Planning Officer:	David Easton
Planning Application Ref:	Y/91/17/OUT
Location:	Land at Bilsham Road, Yapton
Description of works:	Outline application for the development of up to 250 residential dwellings (Class C3) vehicular access, public open space, ancillary works and associated infrastructure. Departure from the Development Plan

- Key.
- RPA for CAT A\* tree to be retained
  - RPA for CAT B\* tree to be retained
  - RPA for CAT C\* tree to be retained
  - RPA for CAT U\* tree to be retained
  - Canopy of tree to be retained
  - Canopy of CAT U\* tree to be removed

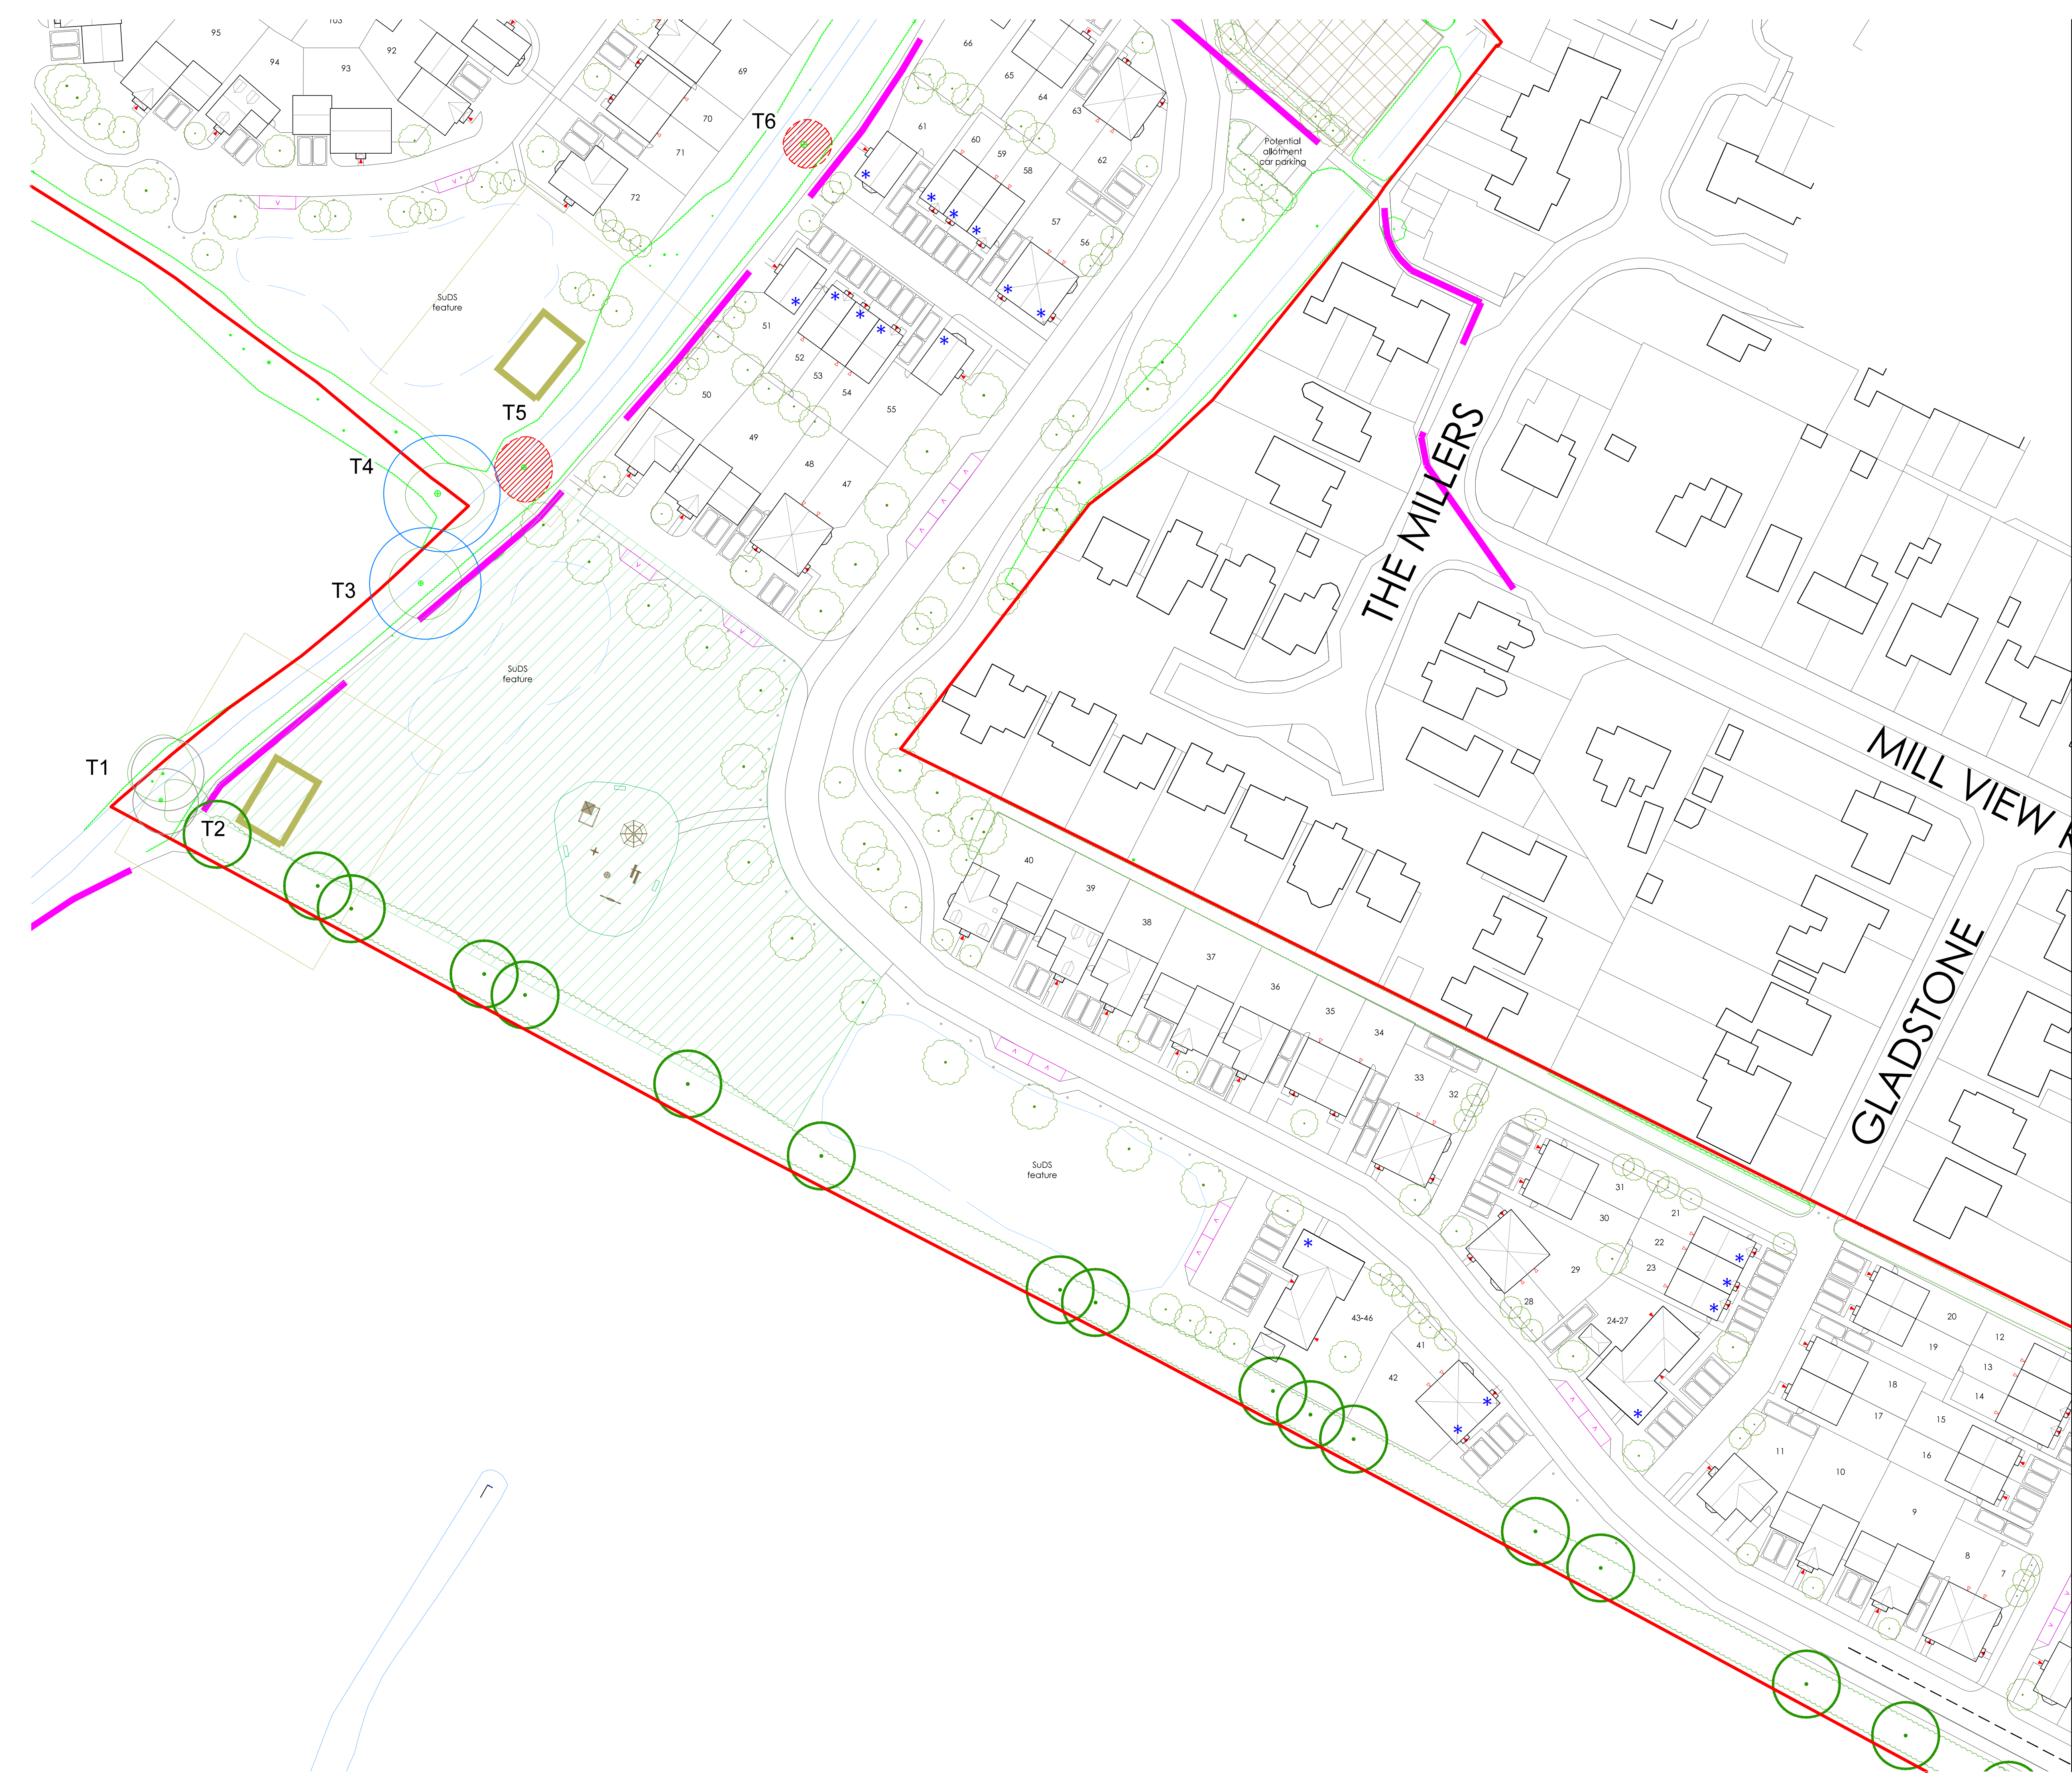
- The applicants employed the PJC Consultancy back in November 2017 to undertake a tree survey and then prepare an Arboricultural Impact Assessment (AIA) PJC/4699/17-02 R2. Tree Survey data is adequate at this stage and broadly accords with the requirements of BS5837:2012. I have referred to Illustrative detailed masterplan drg. 1244G.03 to assist with determining the accuracy of the Tree Constraints and Tree Retention Plans submitted by PJC with their AIA report. This allows me to gain a general understanding of how the plot layout and access routes relate to trees but is not specific enough for me to have full confidence they will be adequately respected and protected. **PJC Consultancy have submitted a revised Arboricultural Survey and AIA, ref. nos 3867/15/01 & /02 - Rev 04 and dated 13th and 14th March 2018 respectively. I have been asked to consider the amendments and provide comment. The supporting text within suggests a well-intentioned plan for significant trees on the site although it lacks the necessary detail to ensure their adequate protection and respect once development is underway.**

- I am pleased to see there is intent to retain the vast majority of recorded trees in harmony with the development, but I cannot be satisfied that this will be achievable until we receive a Tree Protection Plan (TPP) overlaying the final proposed site design layout, with supporting Arboricultural Method Statement (AMS) where RPA (Root protection area) incursion is anticipated - which I would expect to see submitted with a subsequent full planning application.

- At this outline stage, the indicative layout and access arrangements and the appointed arboriculturalist's general regard for significant trees existing on site are encouraging and I am in broad agreement with their survey information. That said, I am concerned that there appear to be notable omissions in respect of existing tree cover along several sections of the site perimeter (South, adjacent arable farmland – East, rear of The Millers – North, south of dwellings at Tack Lee Road). This may be deliberate as the proposed design does not at this stage suggest any direct interference with them but it is important to consider all trees whether they are on or off-site and within potential influencing distance, so as to inform the site layout design which may of course be subject to revision. Any omissions will need to be addressed and therefore included in the aforementioned TPP and AMS should this proceed to a full planning application. **Despite appearing in symbolic form on the Illustrative detailed masterplan drg. 1244G.03, significant trees located within the Southern site perimeter hedgerow were omitted from the tree survey schedule provided by PJC. They are of such dimensions and proximity as to be a material consideration and will require full consideration and appropriate levels of protection before any work can commence on site. I have determined that the majority of these merit a TPO. These trees have now been included in the tree survey schedule and so should be recognised in the anticipated TPP.**
